From: Simon Davis
Sent: 18 February 2019 10:56
To: Planning.Responses
Subject: FW: Beech Cottage, 99A North Bersted Street BE/88/18/DOC CONDITION 6
Attachments: simon davis vehicle method statement.doc; img070.jpg; img071.jpg

From: MARTIN STOCK [REDACTED]
Sent: 16 February 2019 19:35
To: Simon Davis [REDACTED]
Cc: Christopher Tomkins [REDACTED]
Subject: Re: Beech Cottage, 99A North Bersted Street BE/88/18/DOC CONDITION 6

Thank you for your email. We did receive your initial site set up plan. However, WSCC Highways asked for it to be amended with an annotation to state that any reversing vehicle movements out of the site access onto North Bersted Street are undertaken with the aid of a banksman. Please see their email attached. Please amend the plan with the annotation and resubmit to me.

SITE SET UP
BE/133/16/PL
Drawing 2 - Block Plan
Scale 1:500 @ A3

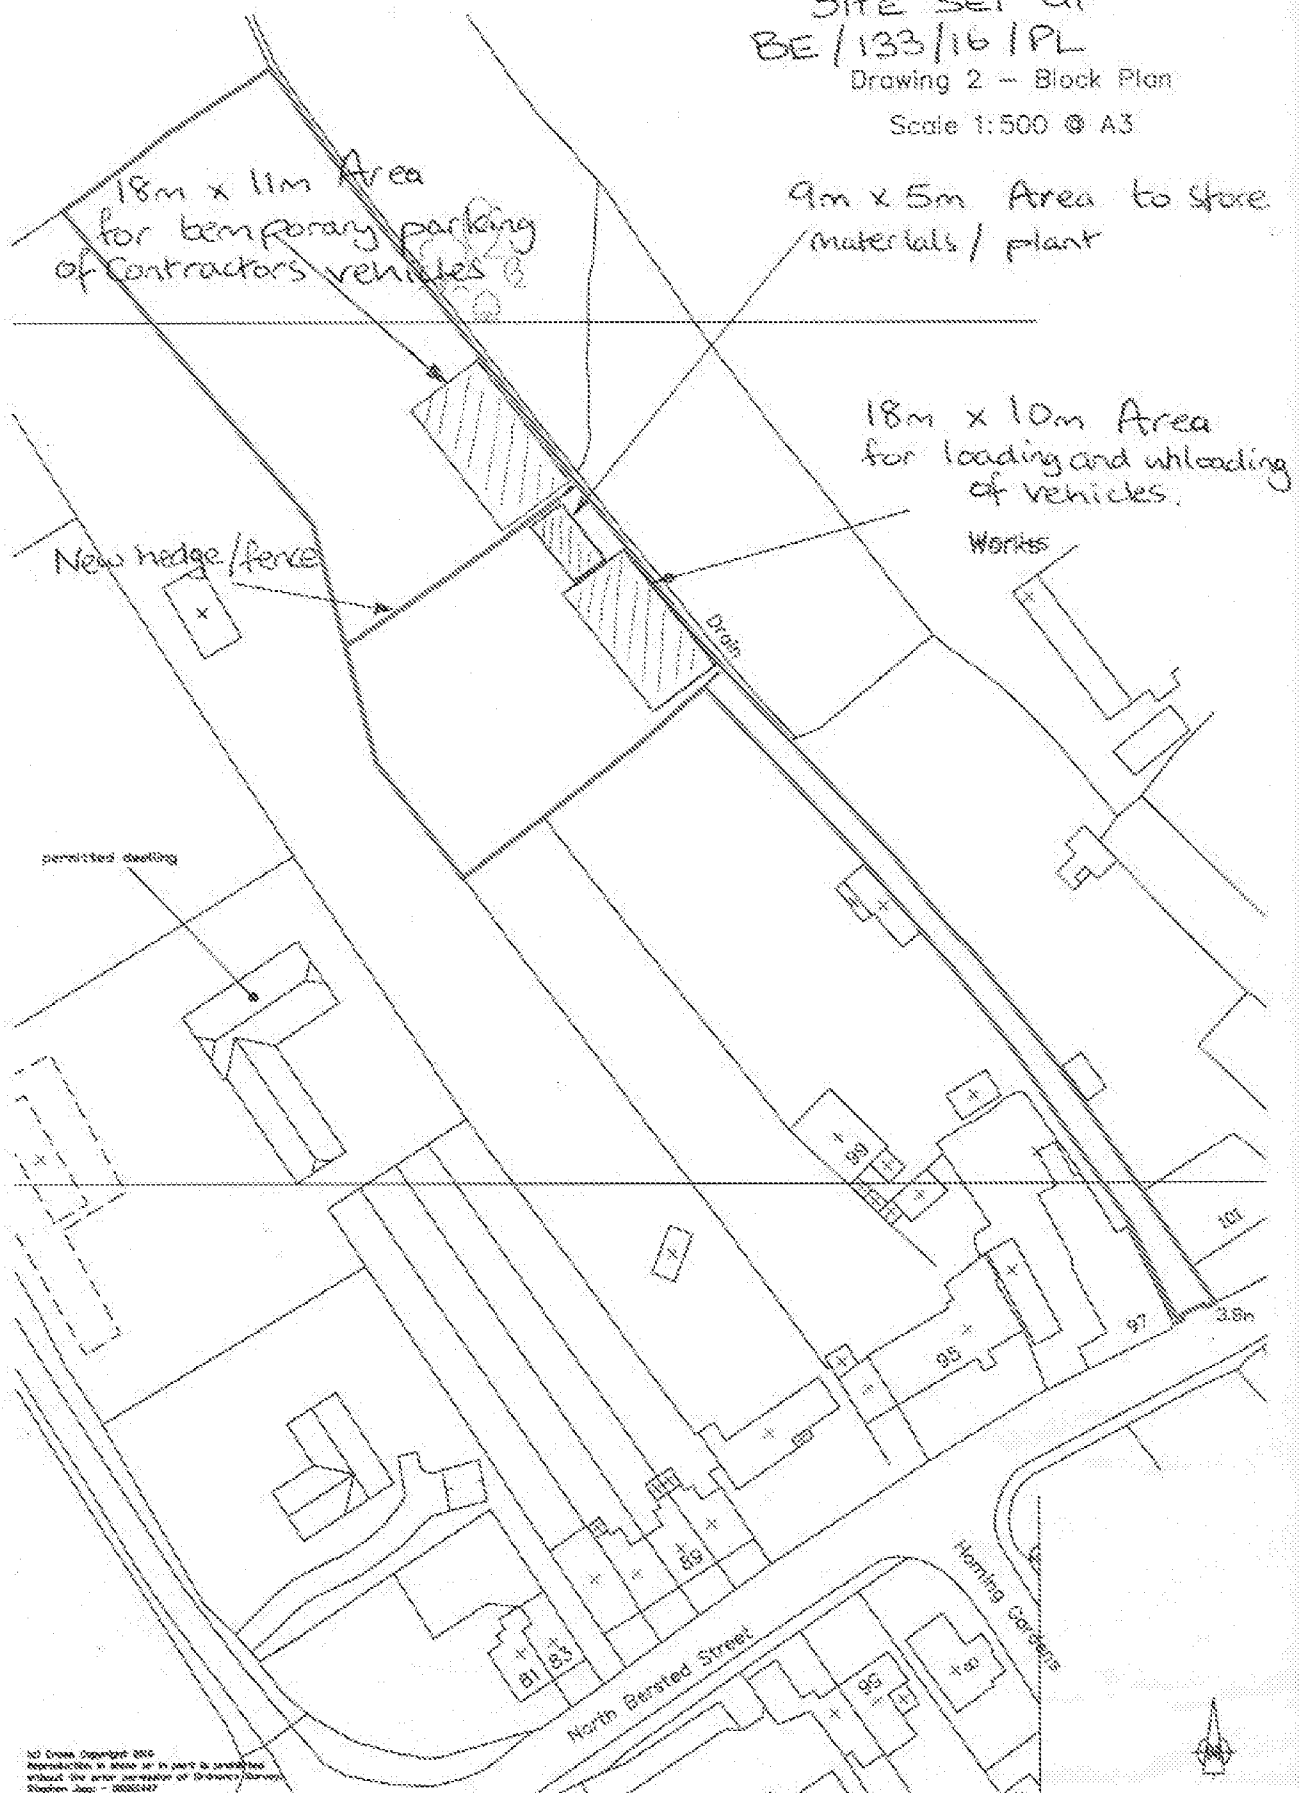
Please see attached advice from Highways re the Construction Management Plan. Can you amend the drawing and respond please.

I have attached a method statement for vehicle movement on the site at North Bersted Street also drawings showing routes and turning areas.

Will do there's no need for any site traffic to reverse into NB Street ample turning and parking

But will amend and return to you
